Application number: 2019/91327	
What is the application for?:	Reserved matters application pursuant to outline permission 2017/90207 for erect
Address of the site or building:	Thongsbridge Mills, Miry Lane, Thongsbridge, Holmfirth, HD9 7RW
Postcode:	HD9 7RW

Type of comment: An objection
Firstly, we would wish to point out that we have no objection in principle to the development of this site for employment uses. However, we wish to strongly object to the current Reserved Matters planning application 2019/91327 on the following grounds - In terms of Local Plan Policy LP24, the form, scale, and layout of the development does not respect nor enhance the character of nearby heritage assets and the landscape in general because it appears that the site is over-developed. Because of their size and layout, the proposed buildings are far too close to nearby residential properties. One of the proposed buildings is two storey in height and is only 5 meters away from the site boundary (which is low stone wall) The proposed building nearest my property will have a significant adverse impact on our residential amenity due to the fact that the scale of the unit will be be overbearing because of

1_Huddersfield Road Elevation 1: 200

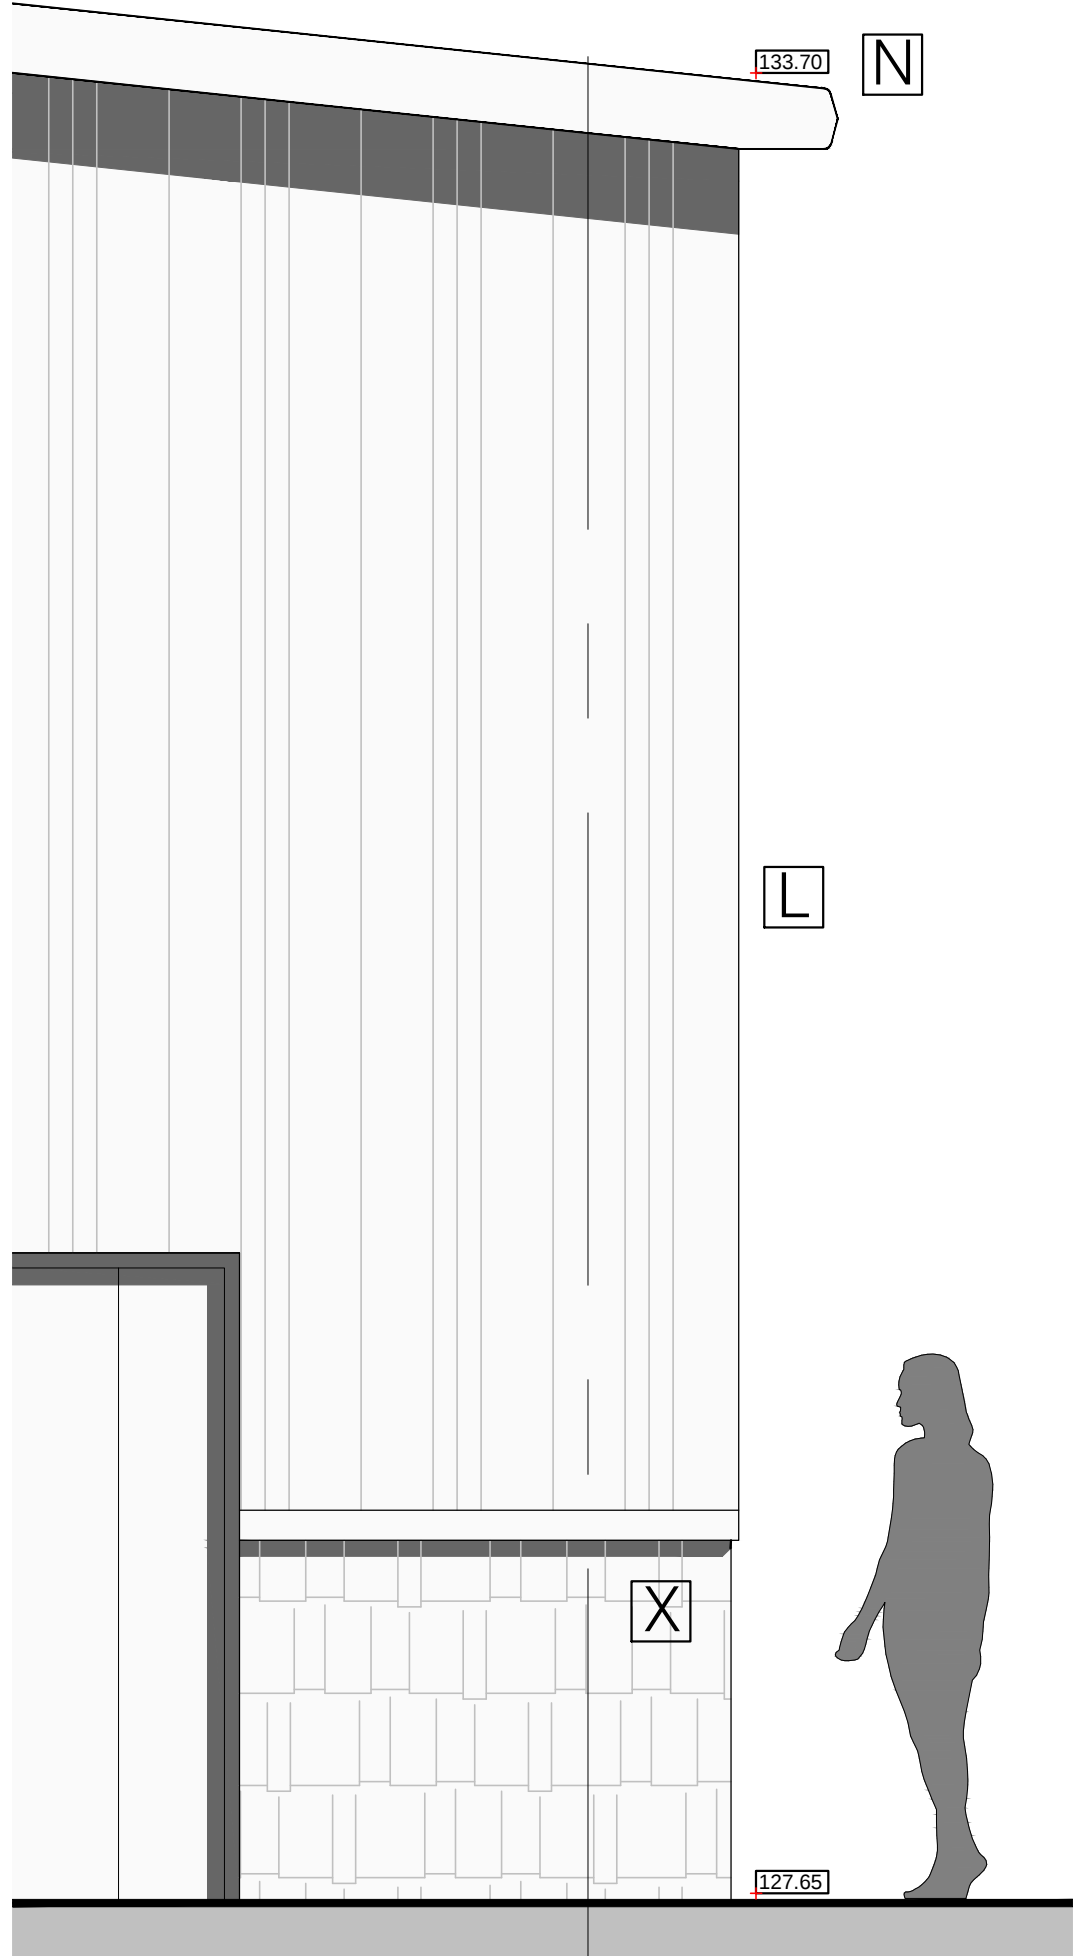
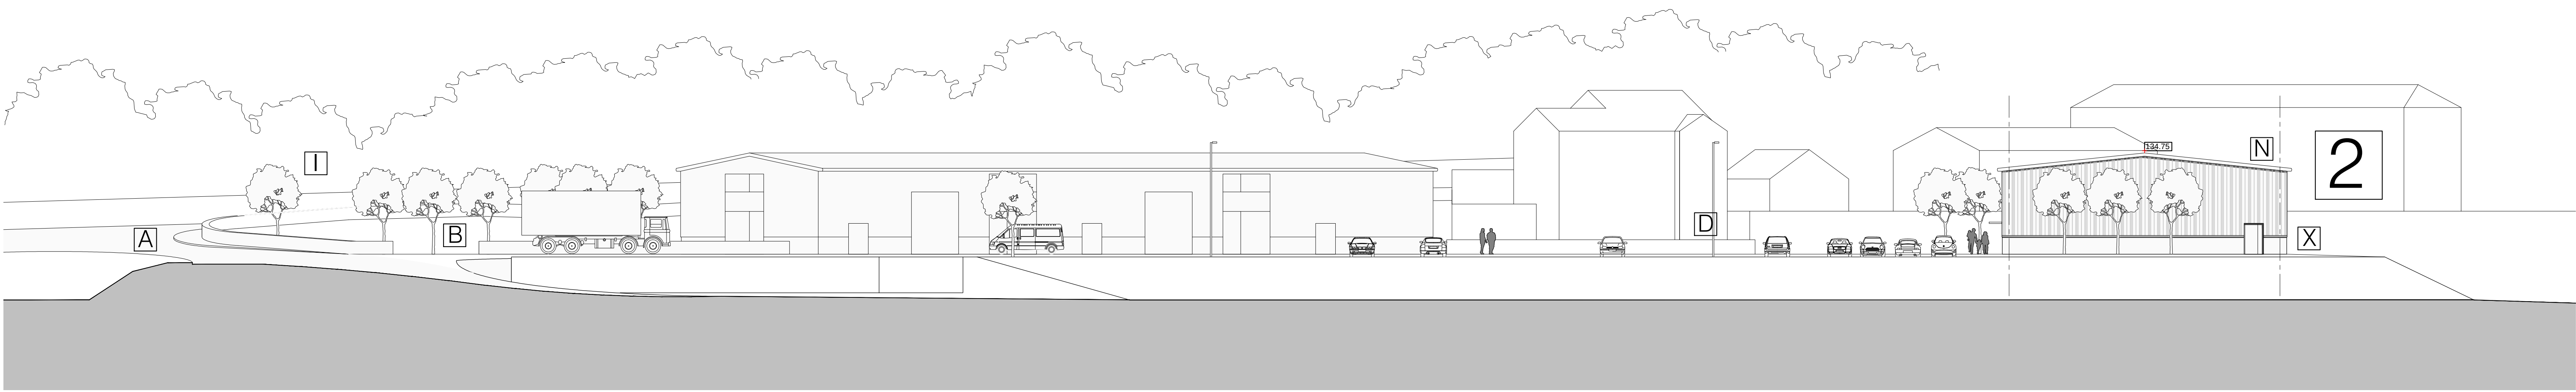
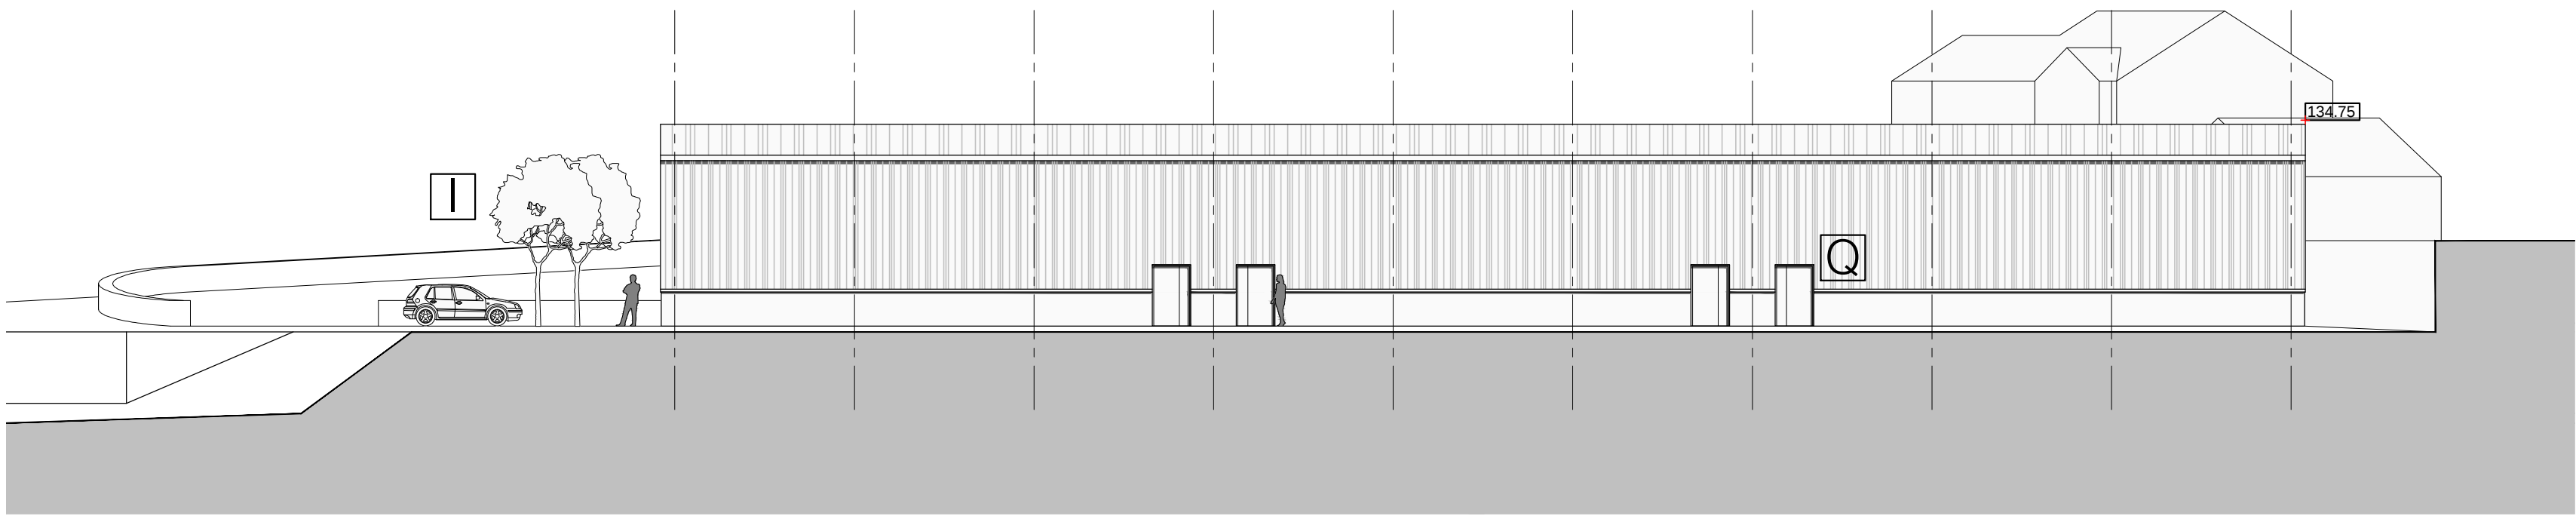
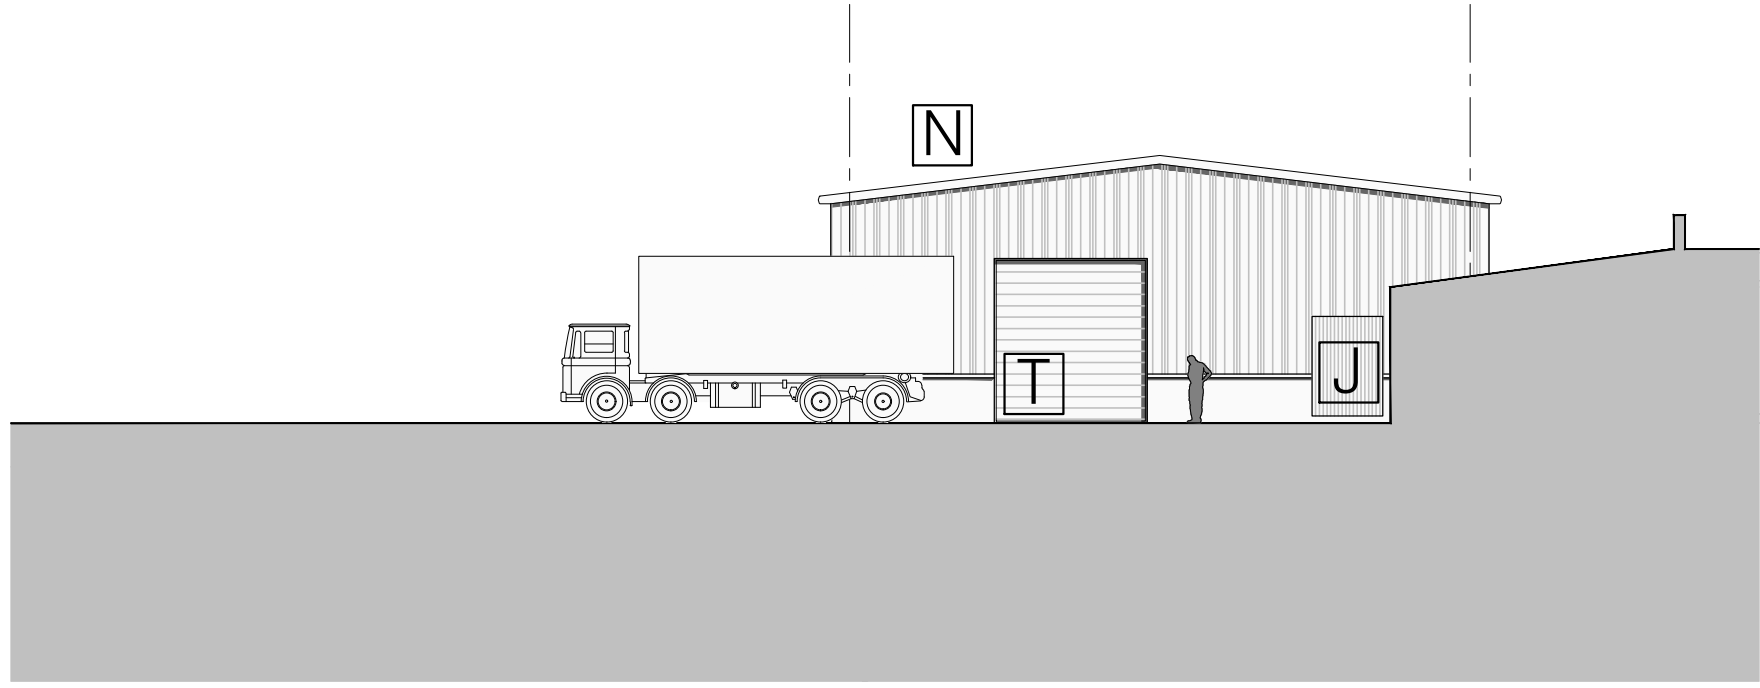
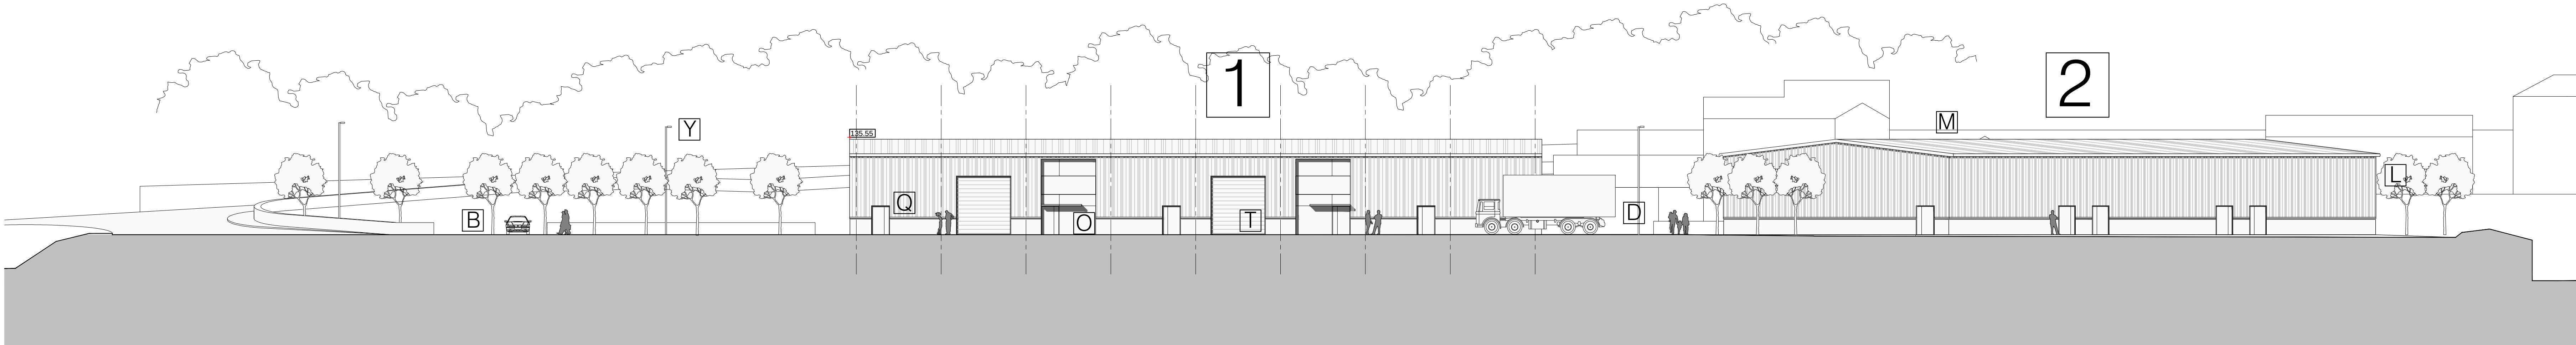
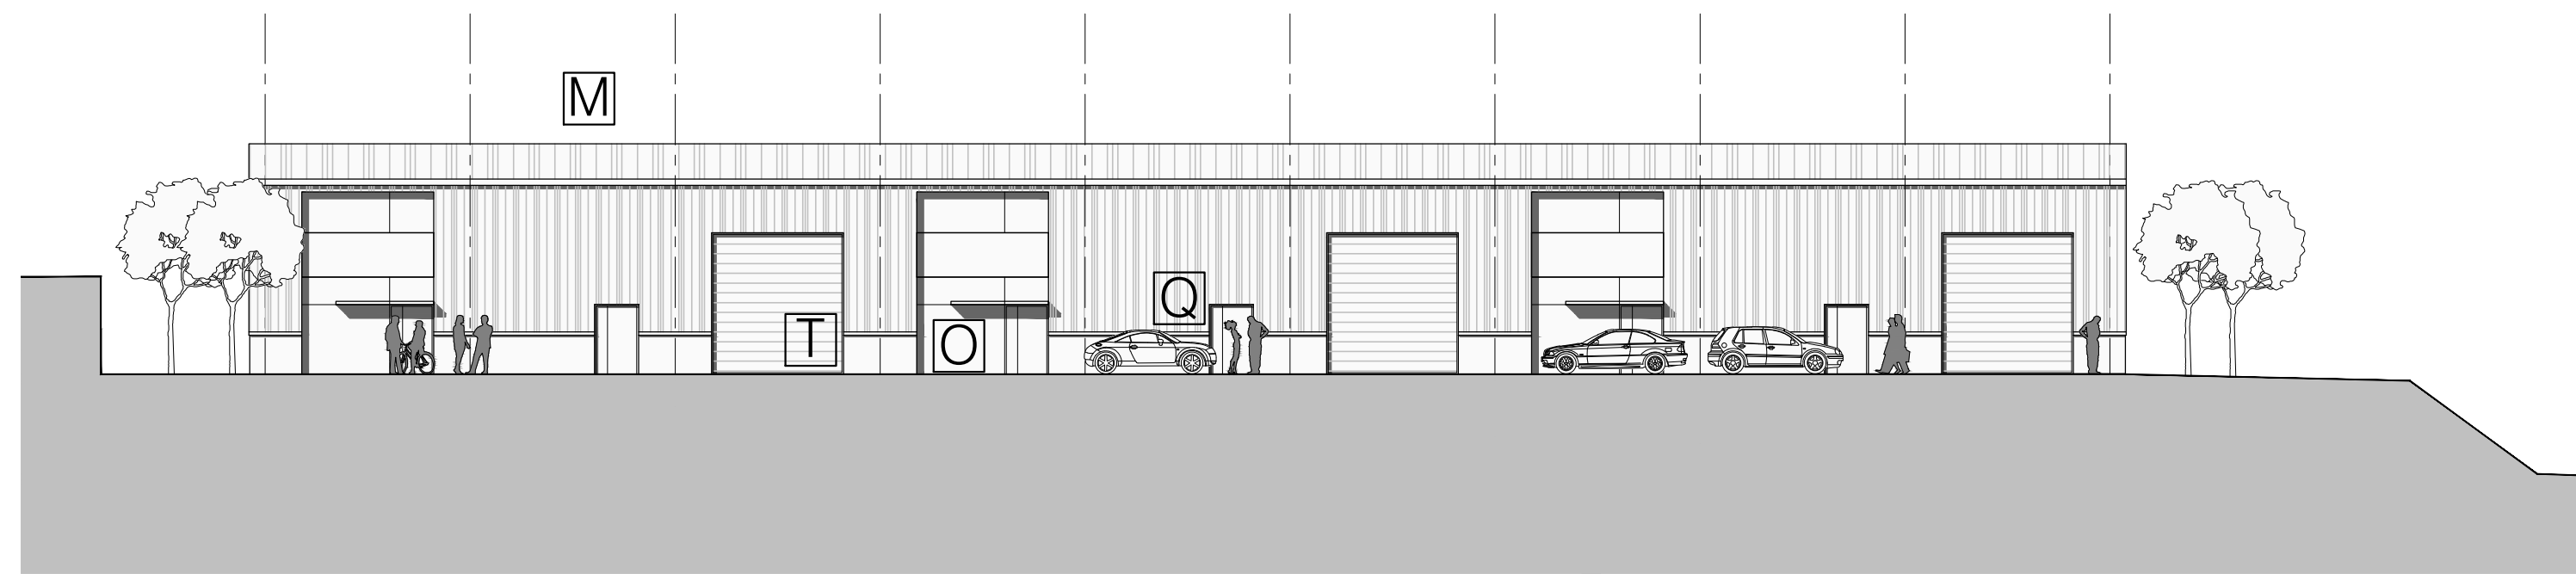
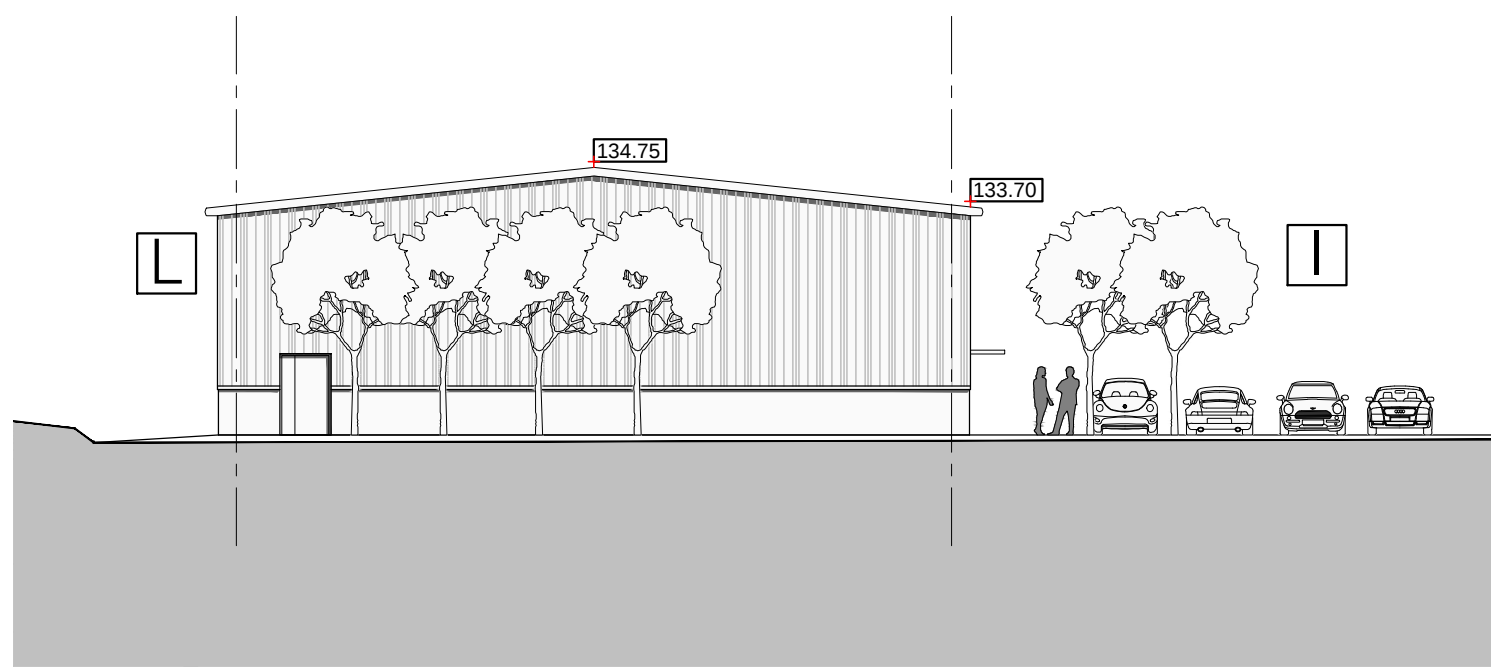
as it makes reference to the substation but this in fact is attached to the rear of Mill Millfields House

Given the above, we would therefore request that the Council seeks amendments to the proposed building (Scale, Appearance, and Layout in the Reserved Matters application) which would have less impact on our property and our residential amenity and which would accord with the previous report to Planning Committee. In terms of
